Rezoning Transportation Analysis

Petition Number: 2022-155

General Location Identifier: 03715511

Date	Description
1-25-23	First Review (TM)

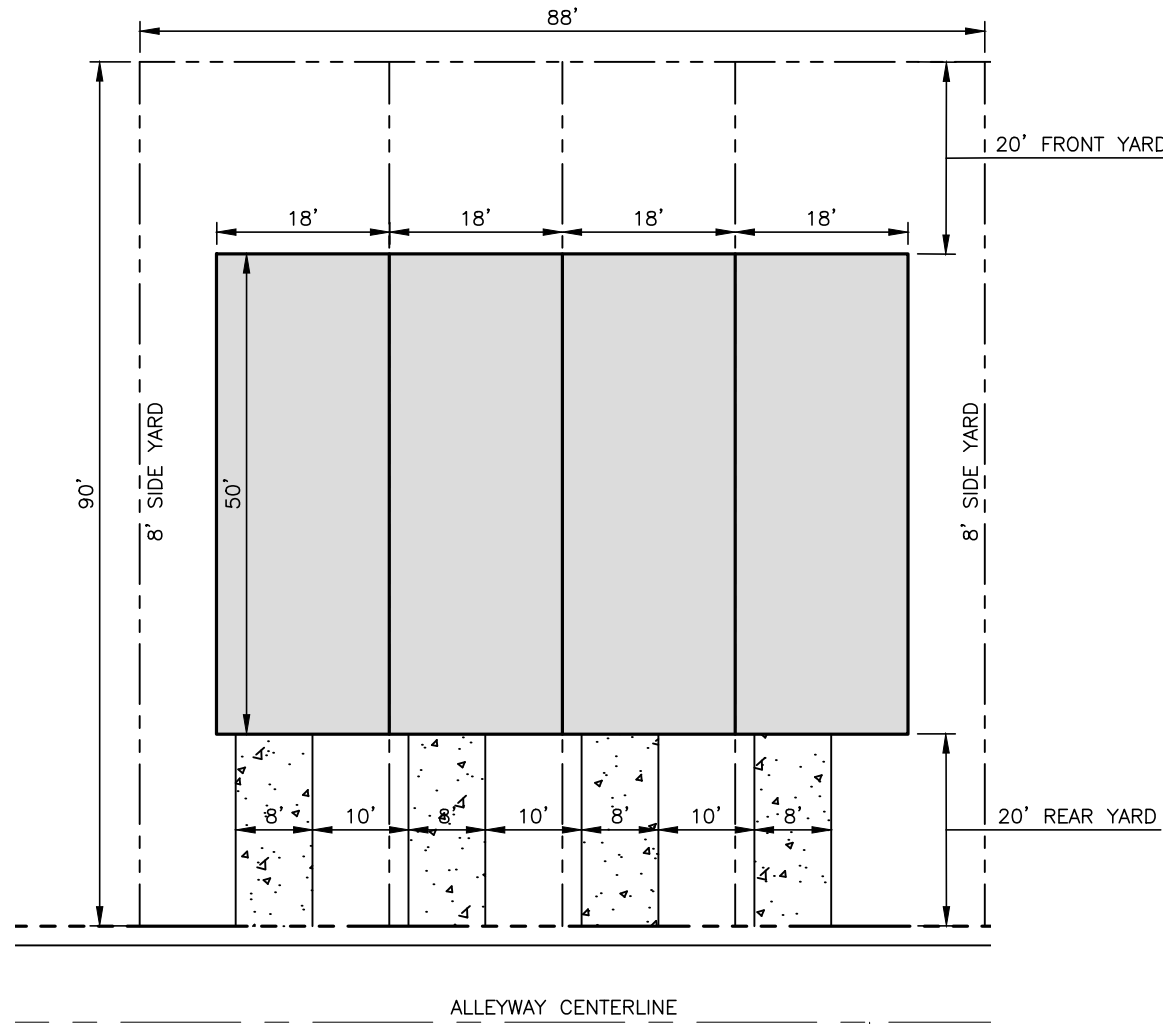
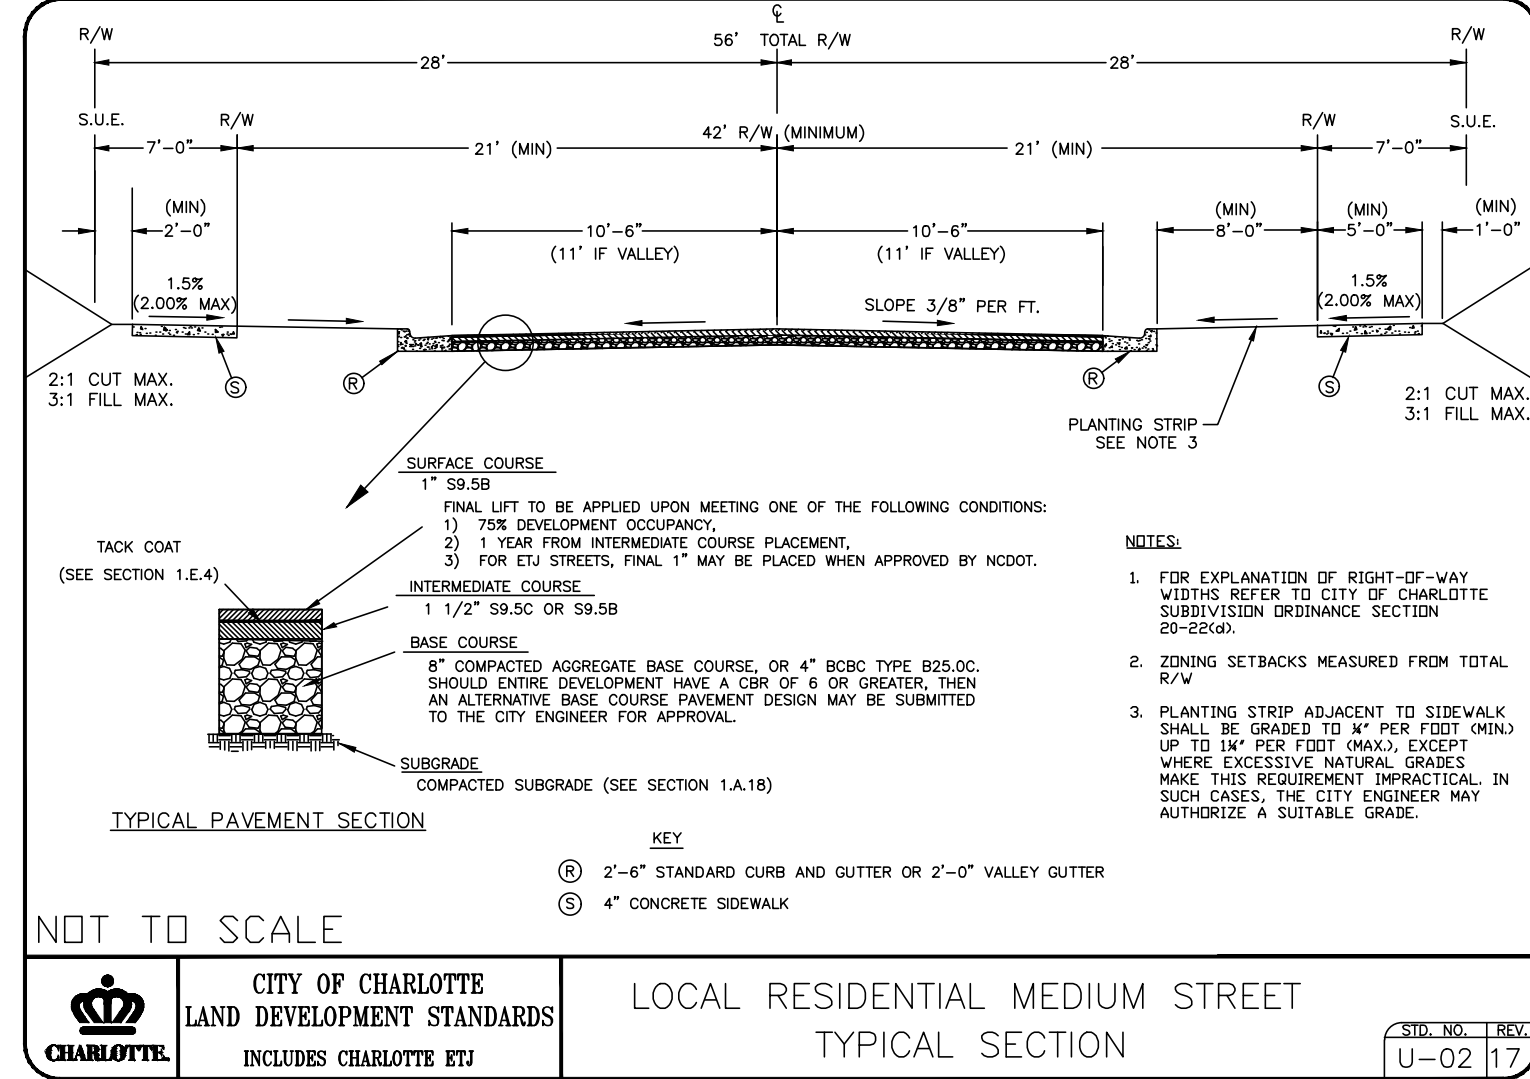
- a. **Lakeview Road:** Location of future curb and gutter to be moved to 30 feet from roadway centerline to accommodate the Charlotte Streets Map with a future roadway typical section of a 4+ Avenue (including a two way left turn lane) and Shared Use Path.

Label and dimension the curb and gutter from the centerline for each road on the site plan.

3. Revise site plan and conditional note(s) to commit to dedicate 28-feet of right-of-way from the road centerline of Roadway A. The site plan shall label and dimension the right-of-way from the road centerline.

4. Revise site plan and conditional note(s) to commit to construct an 8-foot planting strip, and 6-foot sidewalk on Road A per Chapter 19. The site plan shall label and dimension both items from the back of curb and gutter or edge of pavement.

6. Revise site plan and conditional note(s) to commit to completing a developer agreement with the active CIP project prior to permitting approval. Revise site plan to show the updated easement information and CIP project linework including streetscape and ROW that has been previously purchased.

7. Revise site plan and conditional note(s) to commit to extending road A and roadway infrastructure (curb line and sidewalk) to the property line.

8. Revise site plan and conditional note(s) to commit to clearly identifying Road A as standard from the CLDSM. Add standard to the callout of road A as well as add a conditional note committing to constructing roadway A to a CLDSM standard. Site plan shall label and dimension roadway infrastructure from the roadway centerline including ROW.
9. Revise site plan and conditional note(s) to commit to clearly identifying Alley cross sections as a standard from the CLDSM. Add standard to the callout of alleyways as well as add a conditional note committing to constructing them to CLDSM standard.
10. Revise site plan by dimensioning the sidewalk along Alley A.
11. Revise site plan by adding CDOT sight triangles to the intersection of Alley A and Roadway A per CDOT sight distance policy. Show either the 50 x 50 sight triangle or the 35 x 35 sight triangle.
